From: Sarah Burrow <Sarah.Burrow@arun.gov.uk>
Sent: 24 February 2022 10:26
To: Planning.Responses <Planning.Responses@arun.gov.uk>
Cc: Maria Tomalova <Maria.Tomalova@arun.gov.uk>
Subject: RE: Planning Consultation on: BR/285/21/PL

Engineers Comments Regarding Surface Water Drainage

Application No: BR/285/21/PL
Registered: 18th January 2022
Site Address: Rear of 73-75 Aldwick Road Bognor Regis PO21 2NW
Grid Reference: 492696 98785
Description of Works: Change of use from Class E (retail) / B8 storage to C3 residential and the creation of three dwelling units through the conversion of the rear of nos. 73 & 75 and the erection of a part single storey / part two storey rear extension with associated amenity space and refuse / recycling stores.

SURFACE WATER STATEMENT

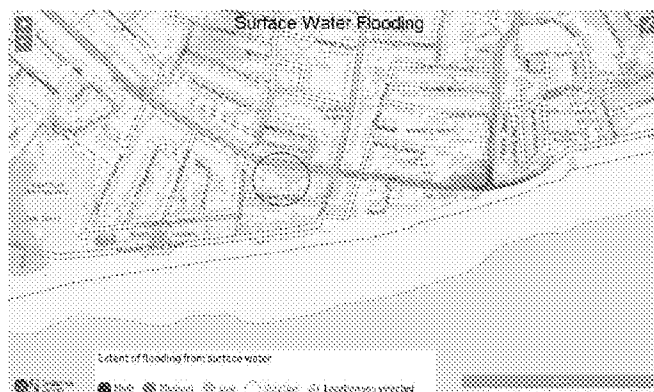
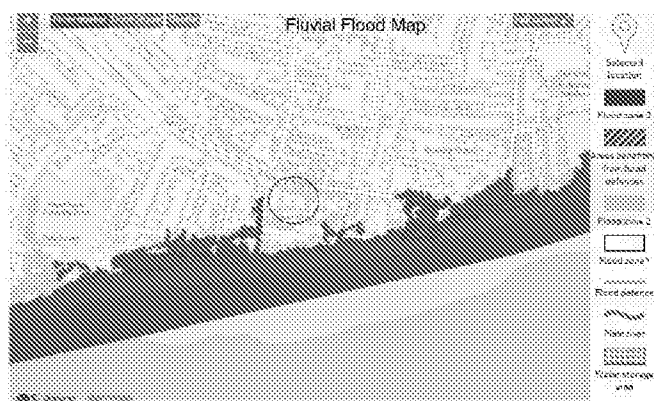
A surface water statement and indicative surface water plan have been supplied by the applicant. These show an intention to drain the site using a soakaway located within the amenity spaces for the proposed units. The applicant has shown that it is possible to locate the soakaway 5m from all buildings and 2.5m from property boundaries.

The final detailed design will need to be supported by winter groundwater monitoring (expected to be for an agreed length of time between December and March) and winter infiltration testing (at agreed time and depth in strict accordance with BRE DG365).

If infiltration is proven to be unviable then we would support a restricted discharge of surface water to the surface water sewer on Aldwick Road (as there are no watercourses in the vicinity of the site).
